Our ref: **CEB/GL/029196**

1st September 2021

Easton Estate – A47 Easton to North Tuddenham Road Improvement Scheme

SECTION 1

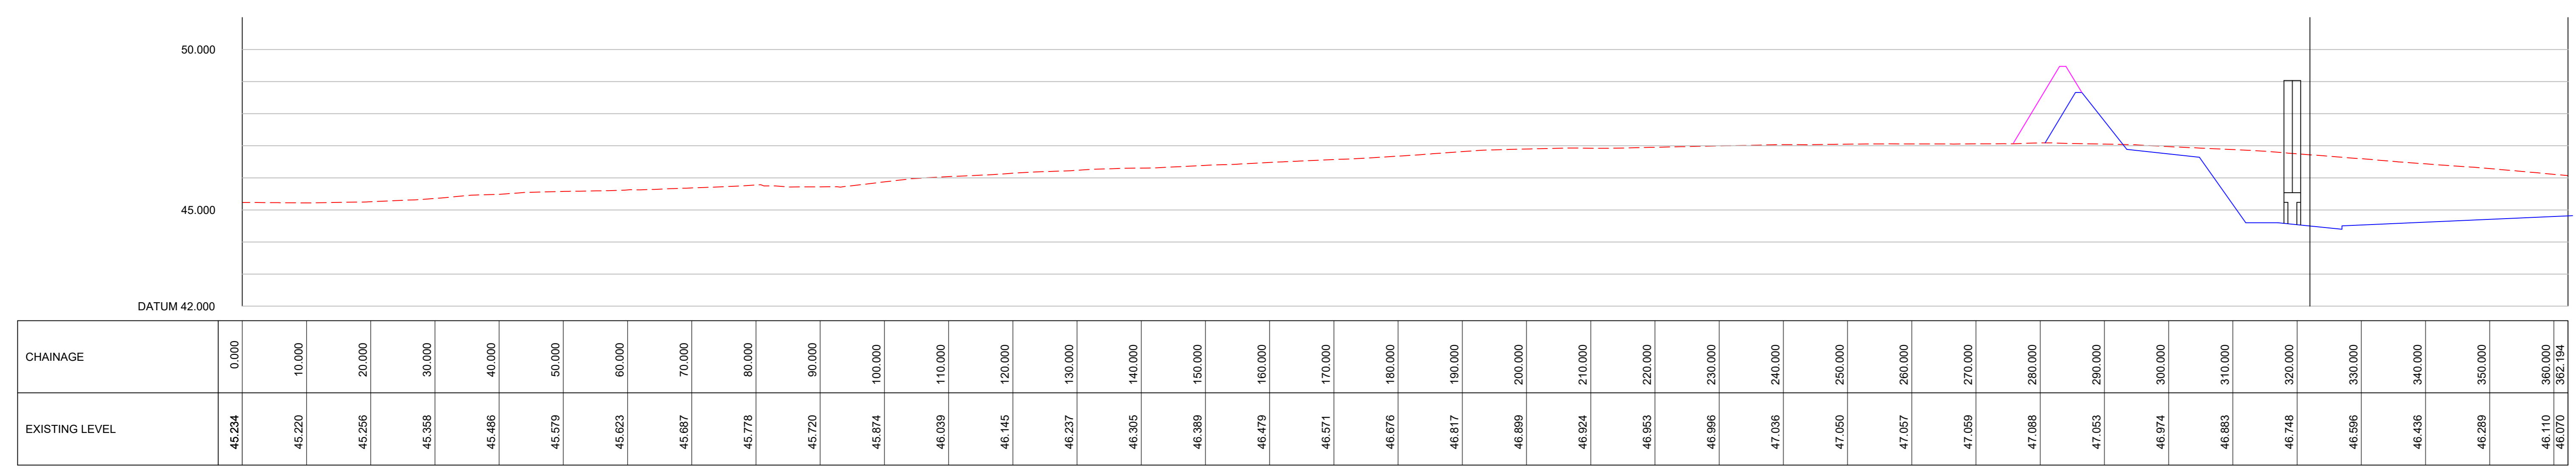
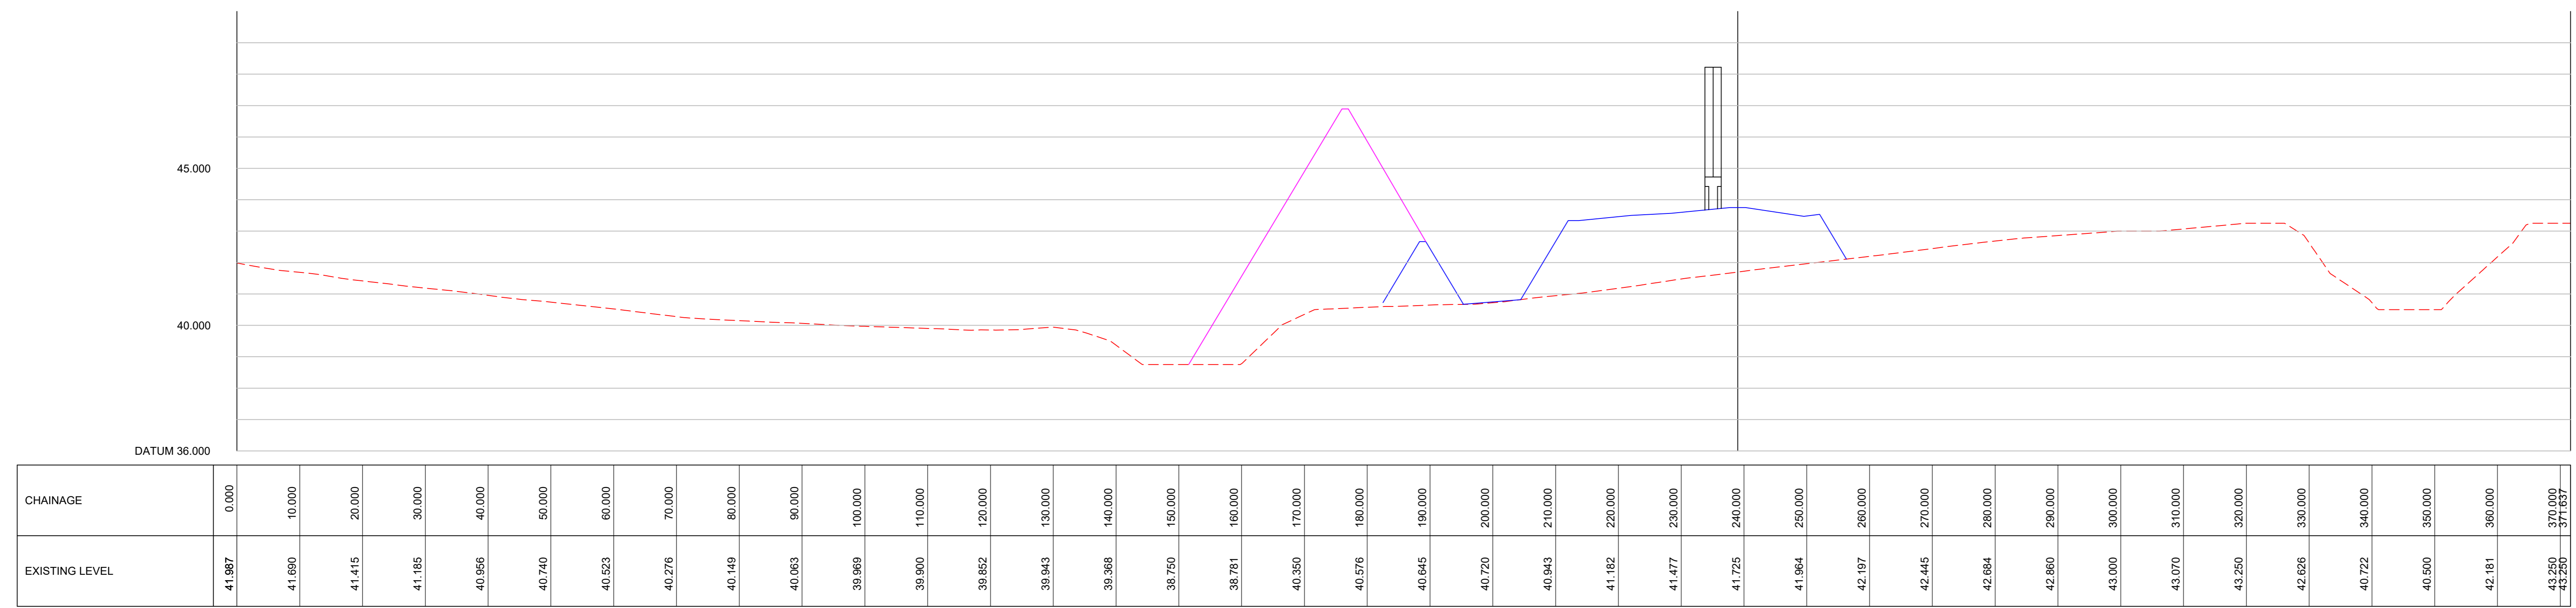
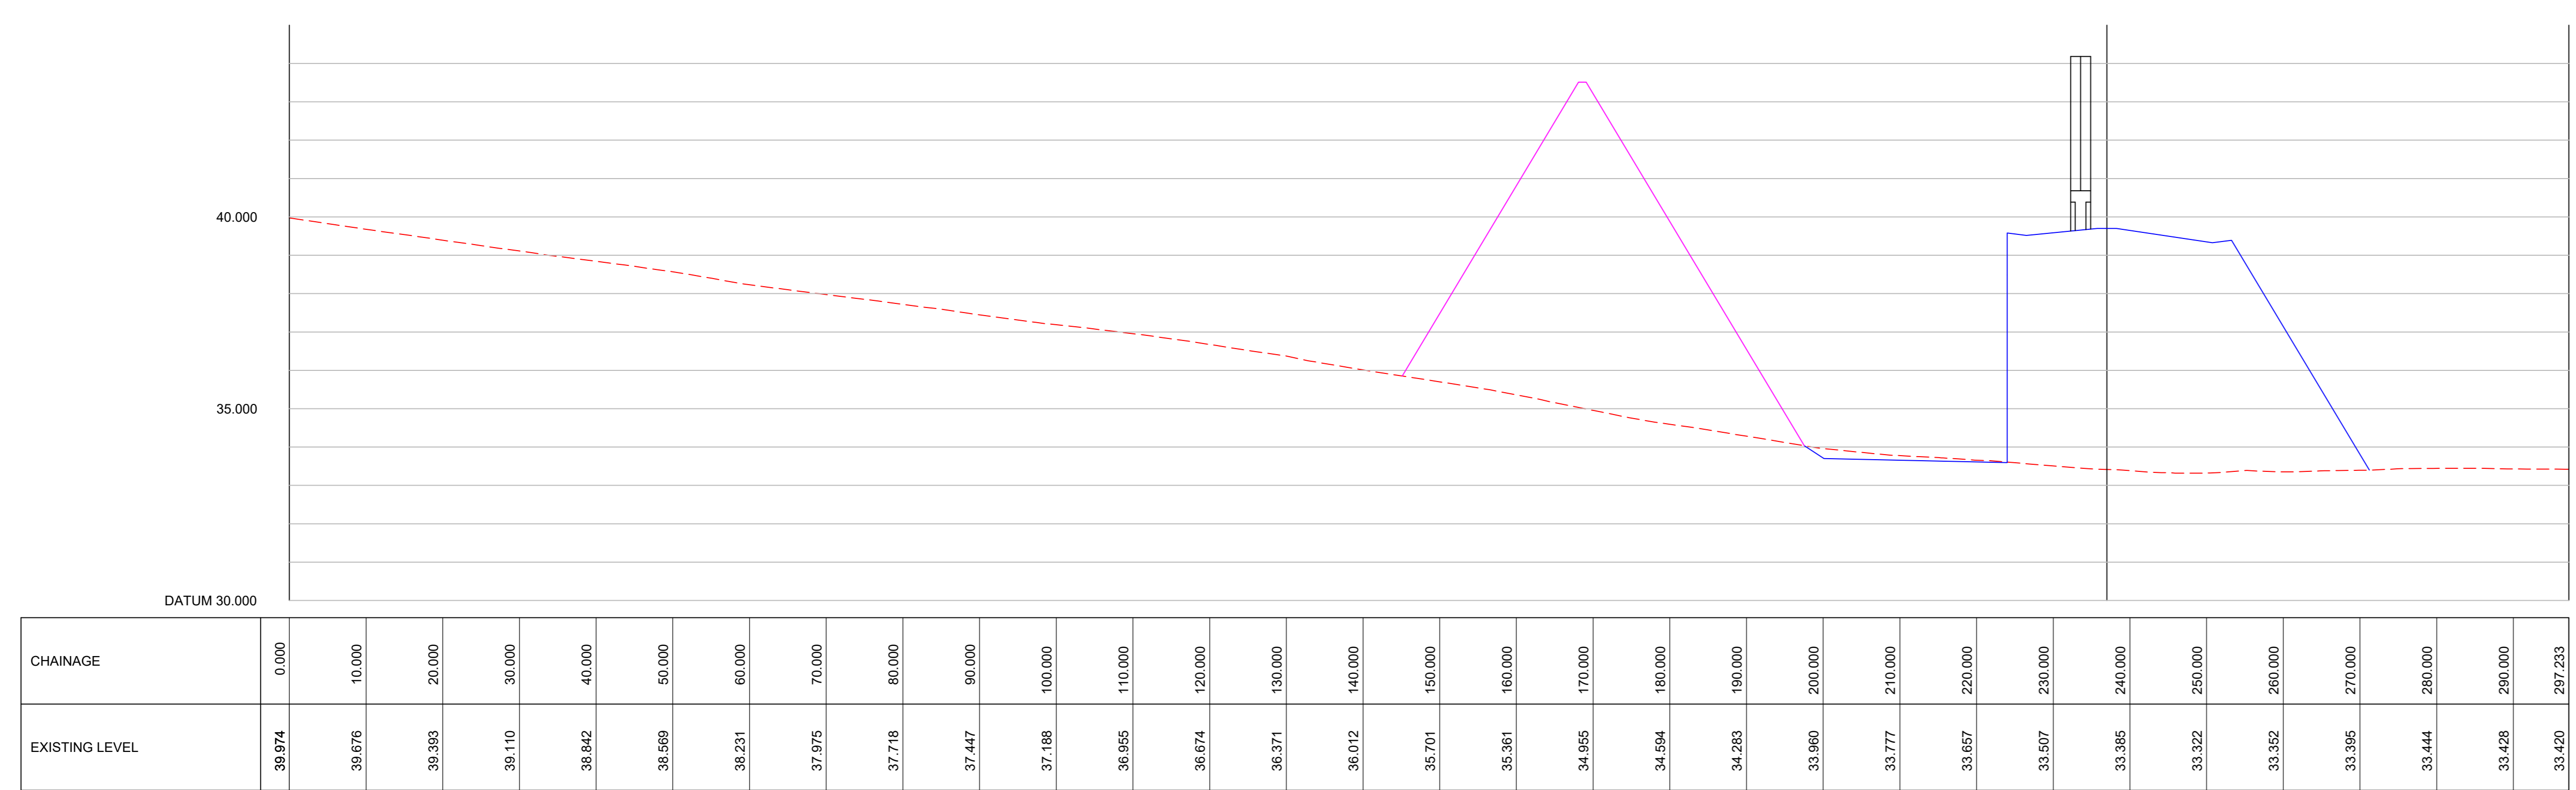
Having repeatedly requested detailed drawings for the scheme works and levels, the Applicant kindly provided these recently, since when we have endeavoured to establish the sections of the road which will cause the greatest intrusion. Without this detail we can only recommend a similar height bank along the whole route, but we remain flexible about where the screening is required most.

We are advised that the Development Consent Order has been drafted to enable the height of embankments to be increased to cater for extra material and for the footprint to be enlarged if further estate land is required from within the red line to enable higher banks. The estate is willing for more land to be used to enable increased protection from the use of the works.

We understand it is likely that more material will be available, so we have confirmed that the estate would be very pleased to receive a 3.5 to 4-metre-high embankment along the entire southern edge, or failing that, between Wood Lane and Honingham Church at least.
